Applicant's Responses to Deadline 7 Submissions

The West Midlands Rail Freight Interchange Order 201X

THE WEST MIDLANDS RAIL FREIGHT INTERCHANGE ORDER 201X
APPLICANT'S RESPONSES TO DEADLINE 7 SUBMISSIONS - DOCUMENT 18.1

drawing / figure number
Figure 12.8

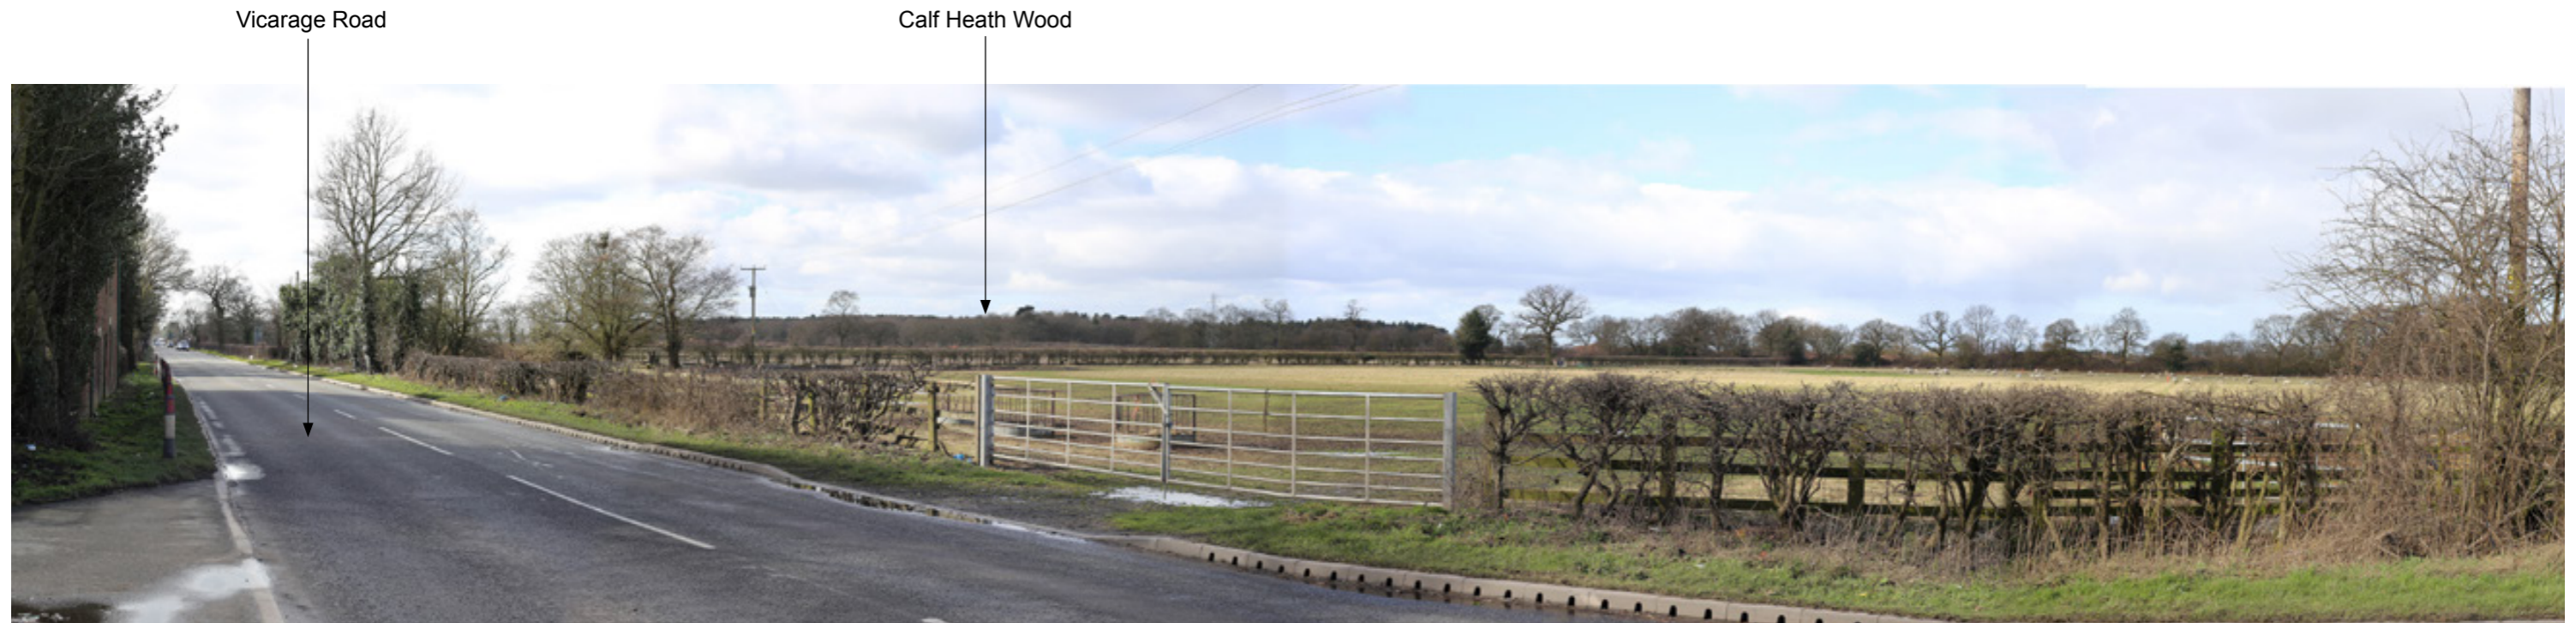
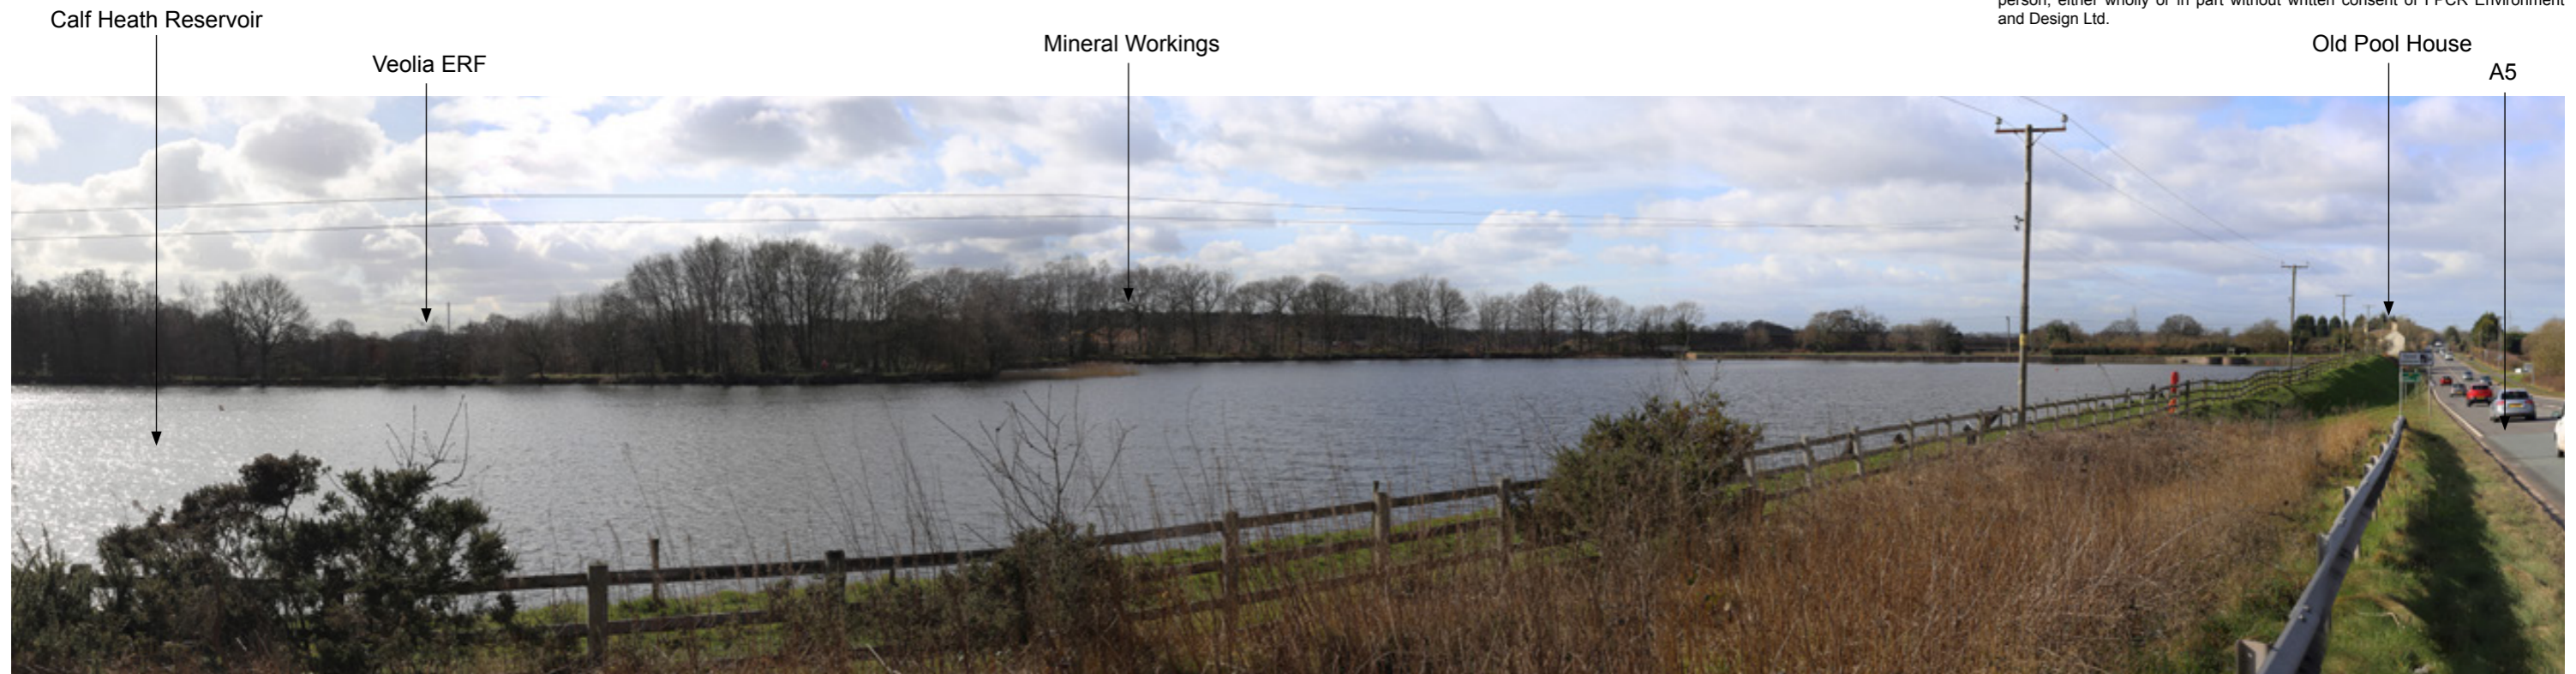
Body / Individual (Reference)	Comment	Applicant's Response
	<p><i>also states that during the design and assessment stage of work, Shareshill was visited by the Applicant together with Officers from the County and District Councils and Natural England. This statement is not entirely accurate; no Officer from South Staffordshire Council (the relevant LPA) has attended such a visit."</i></p>	
<p>The Collective of Parish Councils (REP7-044)</p>	<p><u>Post Hearing Submissions (20015248) – Detrimental Effect on Surrounding Landscape</u></p> <p><i>"The Collective has also identified that there appears to be some confusion regarding the viewing point utilised by the Applicant. The Inspector viewed the site from a specific location, as requested by The Collective, yet the applicant appears to be commenting on what can only be the view from within Shareshill Churchyard itself."</i></p>	<p>The Applicant's understands the Collective are referring to 08 CPC 007 of the Applicant's Responses to Other Parties Deadline 4 Submissions (REP5-006). This response refers to the nature of the visual effects from both the northern side of Shareshill (see Viewpoint 34; Figure 12.8; ES Chapter 12; Doc 6.2) and in relative terms from the churchyard. It confirms that any available views from the churchyard will be restricted by existing trees and hedgerows immediately around the church.</p> <p>The visual effect of the proposed development upon users of the public right of way that includes Viewpoint 34 is detailed at Receptor P5; ES Appendix 12.6; Doc 6.2).</p>

Body / Individual (Reference)	Comment	Applicant's Response
		It should also be noted that all of the photoviewpoints and photo montage locations were agreed with officers of SSDC, SCC and Natural England. Further details on this are provided at REP7-039 above. The SOCG between the Applicant and SCC (REP2-007) confirms the agreement of the viewpoints.
<p>The Collective of Parish Councils (REP7-044)</p>	<p><u>Post Hearing Submissions (20015248) – Ecology</u> The Collective of Parish Council's presented bird survey data, with a number of queries relating to the provision of mitigation areas (see p.9 onwards of REP7-044).</p>	A separate note responding to the query regarding wildlife mitigation areas and bird survey data as submitted by the Collective of Parish Councils is provided at Appendix 3 .
<p>The Collective of Parish Councils (REP7-044)</p>	<p><u>Post Hearing Submissions (20015248) – Conclusion</u> <i>"In conclusion The Collective of Parish Councils would ask the Inspector to refer to the decision of the Ministry of Housing and Local Government to dismiss the Appeal by Roxhill Developments Limited relating to land adjacent to the South Eastern Train Depot, Moat Lane, Slade Green, Erith (Appeal reference APP/D5120/W/173184205 and</i></p>	It is not possible or appropriate to compare the site and proposals at Slade Green with the WMI proposals in respect of detailed technical matters which are dependent upon the unique circumstances of each site. The conclusions in respect of the Slade Green site are specific to the circumstances relating to the M25 and J1A and do not apply to WMI.
